**NSIP Reference Name / Code: National Grid: Bramford to Twinstead Reinforcement / EN020002  
Registration Identification Number: 20041359**

**Title: Natural England's Comments on Document 8.5.12: Technical Note on Ancient and Potential Ancient Woodland and Issue Specific Hearing 4, Action Point One (Table 5.1) of Document 8.6.3: Applicant's Response to the November Hearings Action Points (CAH1, ISH2, ISH3, ISH4).**

**Examining Authority's submission deadline 5: 1 December 2023.**

b) Hintlesham Hall and Hintlesham Woods

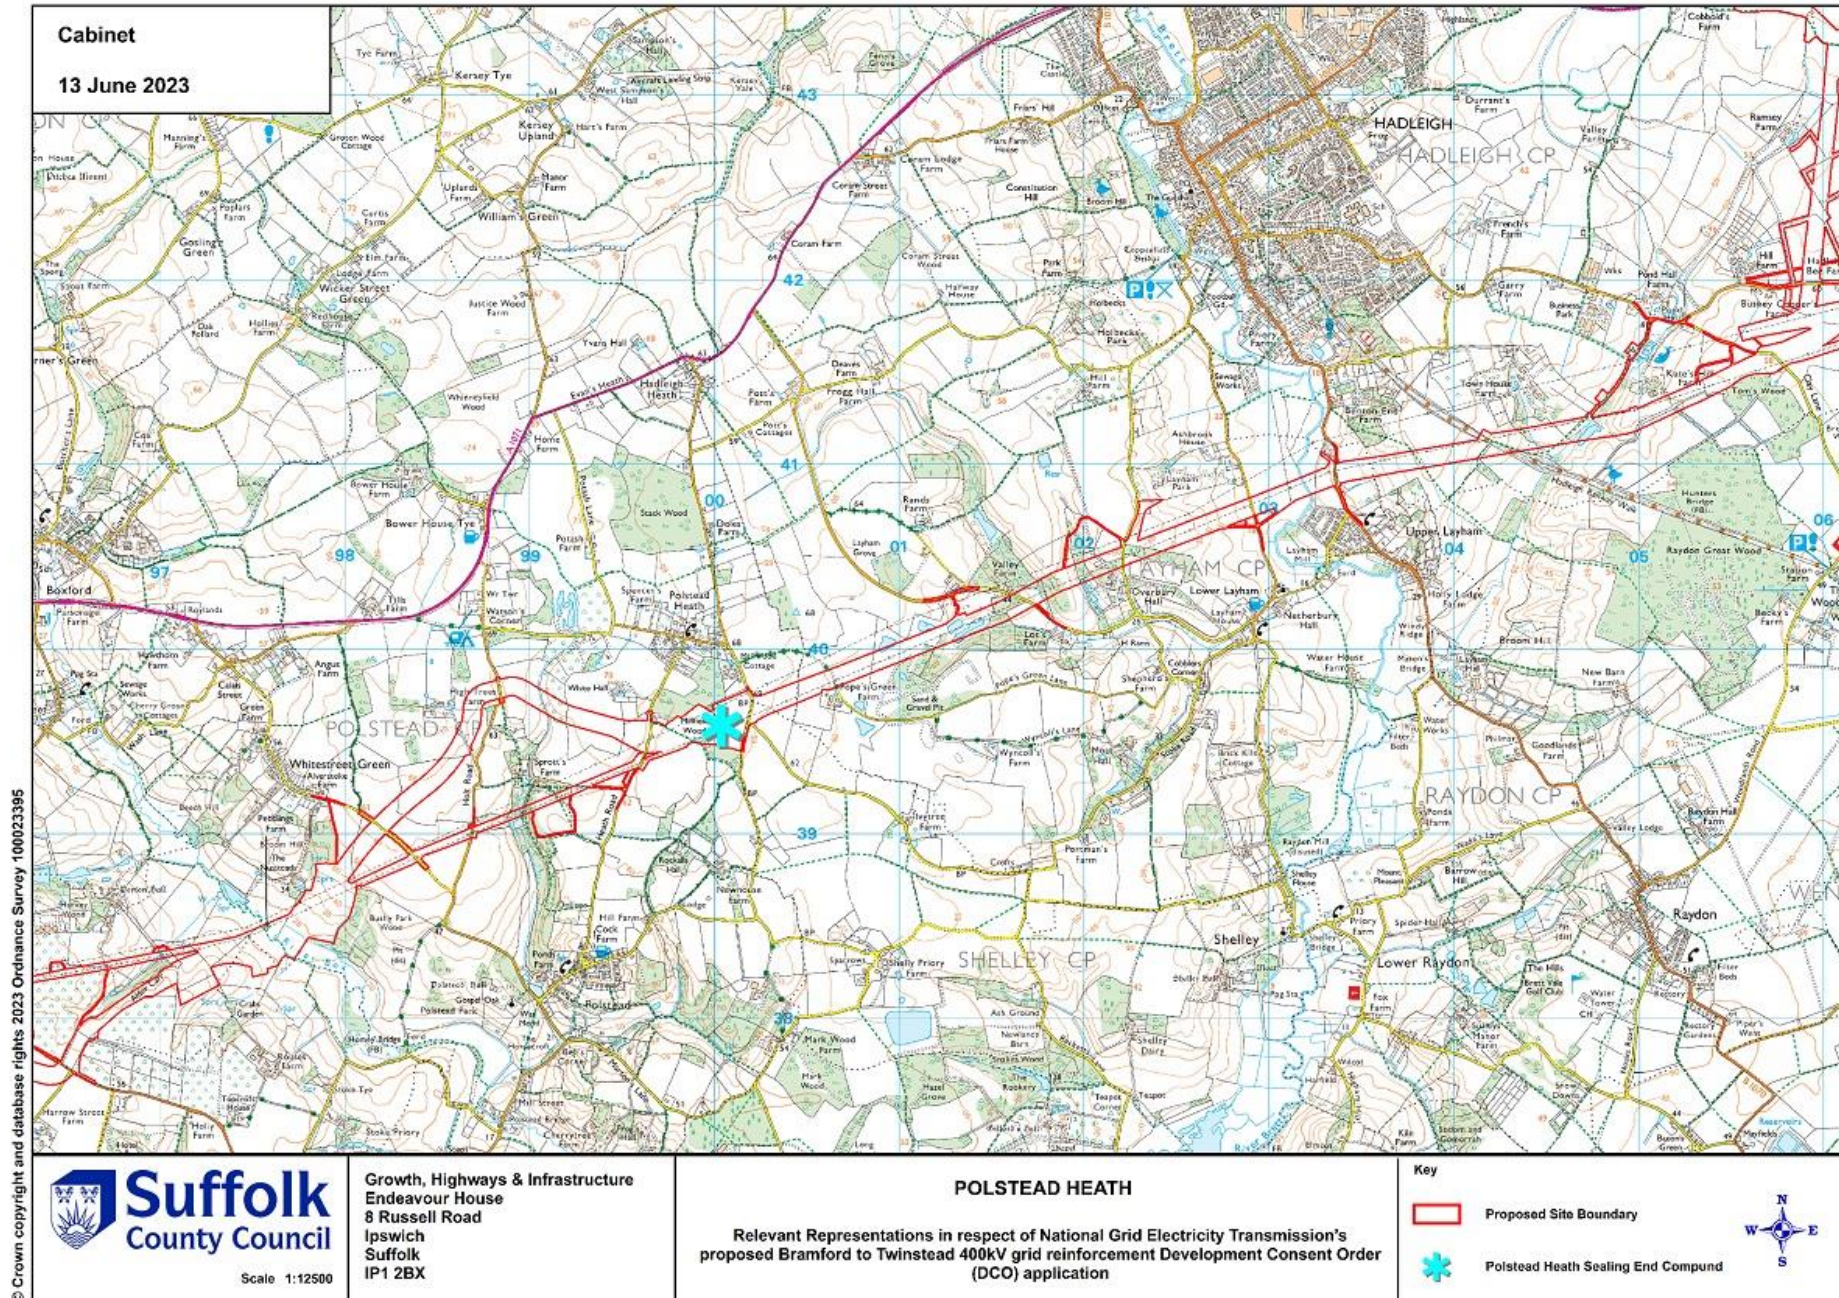
- 3.1. It is acknowledged that the Applicant proposes a further commitment at Keeble's Grove, which is part of Hintlesham Woods SSSI, that it will, "*not be topsoil stripped in order to avoid impacts to the root protection area of this woodland.*" The soil is a key part of the woodland ecology and topsoil stripping of any ancient woodland should be consider as loss or damage. It is important to emphasise that driving vehicles within the buffer zone should also be avoided. As stated in paragraph 2.5.2 and illustrated in Fig. 2.5 of the technical note, a temporary access route will run adjacent to Keeble's Grove and it is not clear what distance this is from the woodland edge. Natural England would advise that a buffer zone, as described in the Standing Advice, should be applied to avoid compaction of the soil.

- 3.2. With regards to Wolves Wood (also part of Hintlesham Woods SSSI), paragraph 2.4.2 states, *“Although the Order Limits lie within 15m of the wood, the only works associated with the project are the instruction of a bellmouth to access the field to the south of the A1071. The bellmouth lies to the south of the road, the road would therefore provide a buffer between the proposed works at the bellmouth and Wolves Wood.”* Natural England advise that the road doesn’t provide a buffer. The road itself means that there is already a compaction zone causing below ground impacts. It is important to note that a buffer zone following our standing advice would also prevent above ground impacts. Consideration should be given to the habitat that could be provided within the buffer zone, above ground (as detailed in paragraph 2.2. of this letter).

- 3.3. In Natural England’s Relevant Representations, we asked for clarity on the need for hand digging/vacuum excavation at Hintlesham Little Wood (part of Hintlesham Woods SSSI). Natural England welcomes the Applicant’s comments in paragraph 2.2.9. of the technical note, which states, *“no excavation works are proposed within 15m of Hintlesham Little Wood.”* Again, Natural England reiterates the need to apply the Standing Advice, with 15m being the minimum buffer zone required, dependant on other factors.

Note: Hintlesham Woods (SSSI)

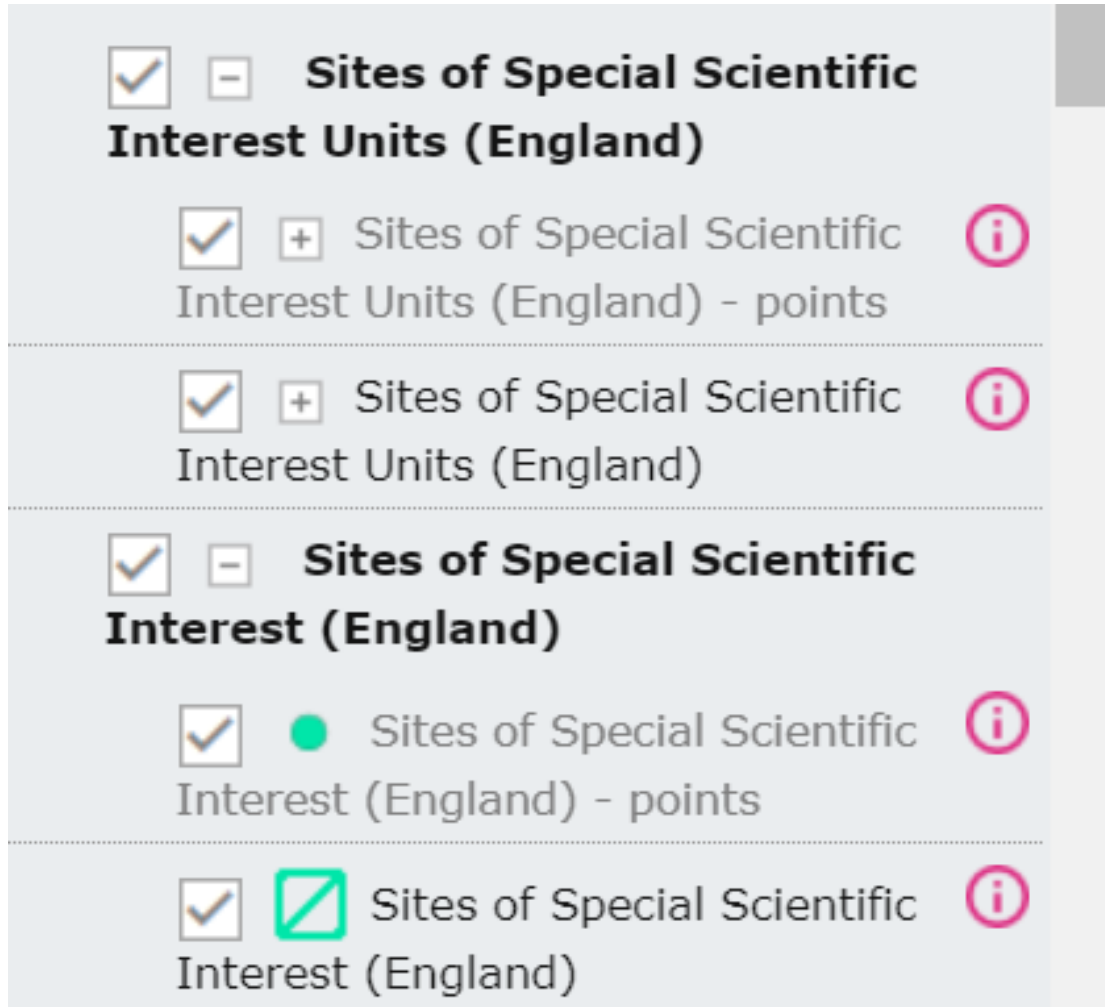
- 7.1. Natural England welcomes confirmation from the Applicant in their response to Action Point 1 of Table 5.1 that the works and ongoing maintenance at Hintlesham Woods SSSI will not extend beyond the existing maintenance swathe. Natural England would welcome the addition of this commitment to the Landscape and Ecological Management Plan, including details of how it will be assured that works will not stray beyond the existing managed swathe, which was discussed with the Applicant in a meeting on 22 November 2023.
